From: Paul Cann
Sent: 29 August 2017 15:52
To: Planning.Responses
Subject: RE: Planning Consultation on: FG/135/17/PL

APPLICATION NO: FG/135/17/PL

Site Address: South Point Beehive Lane Ferring BN12 5NL

Description of Works: Erection of 1 no. 2 bed dwelling

Proposed Block Site Plan - 1:200 @ A1

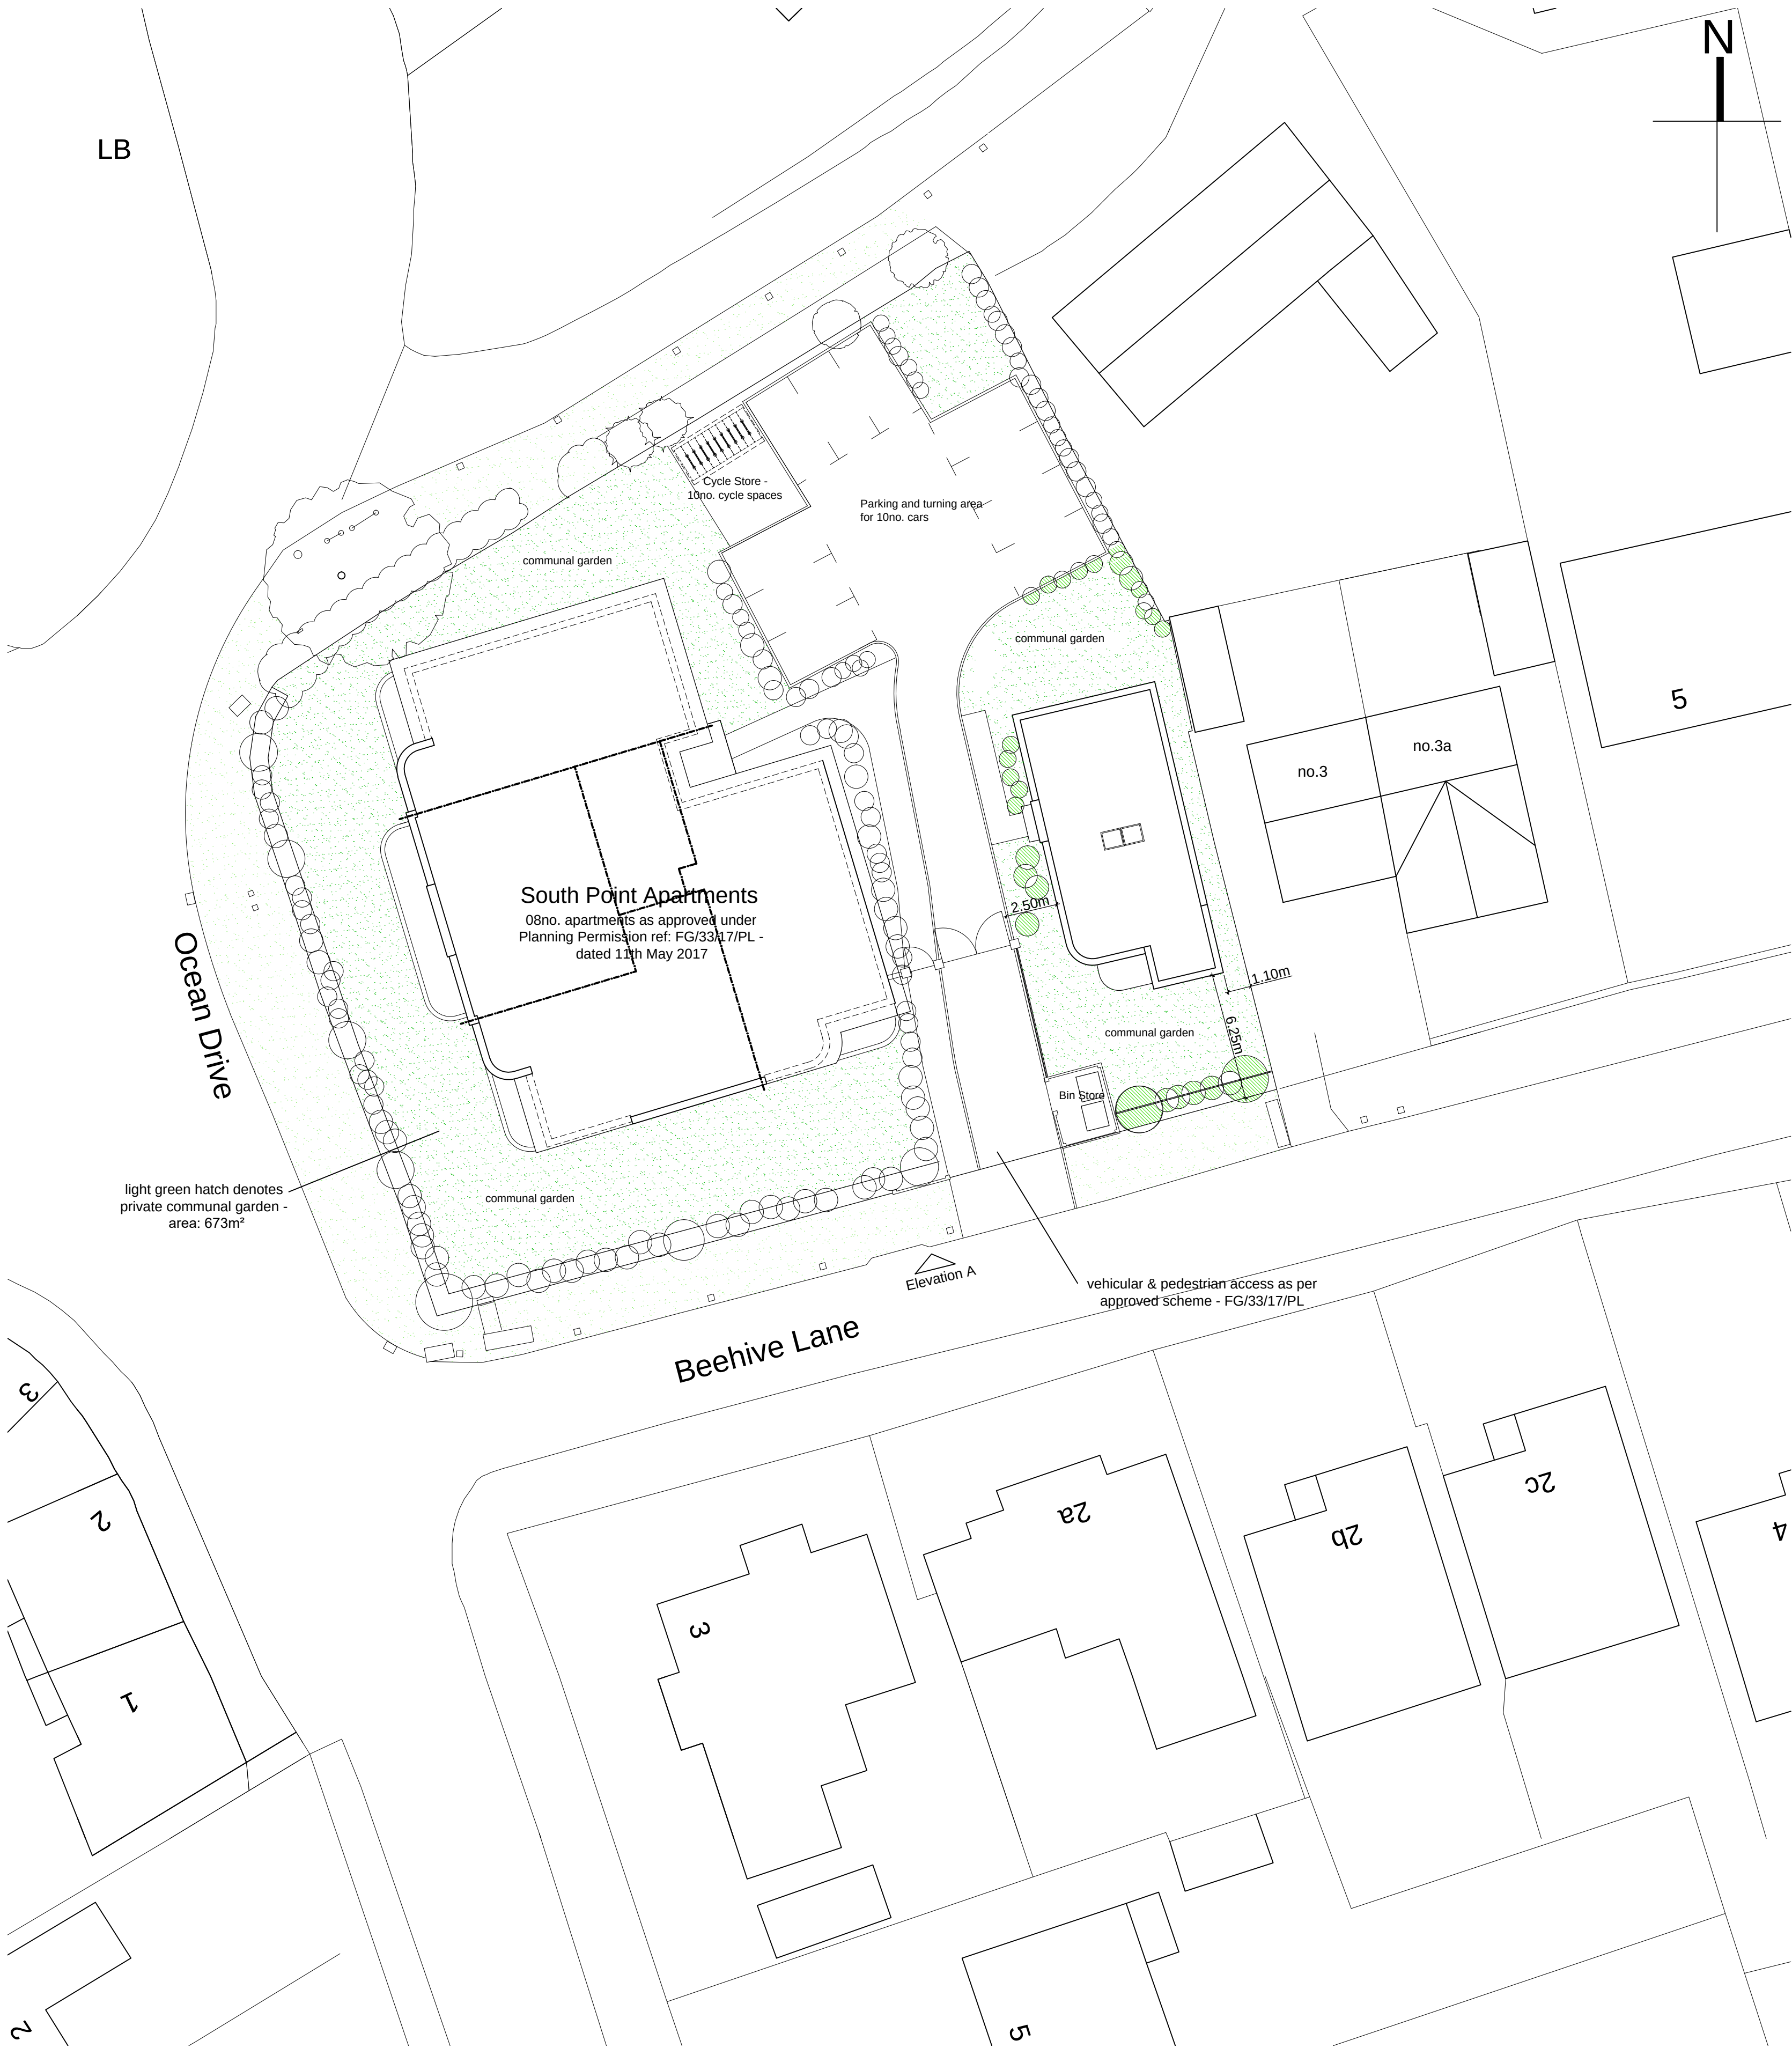
The proposal will affect the surface water drainage scheme proposed/approved under FG/33/17/PL. The applicant will therefore need to investigate the necessary modifications and submit a revised scheme to cater for the additional dwelling.

Please apply a suitable condition.
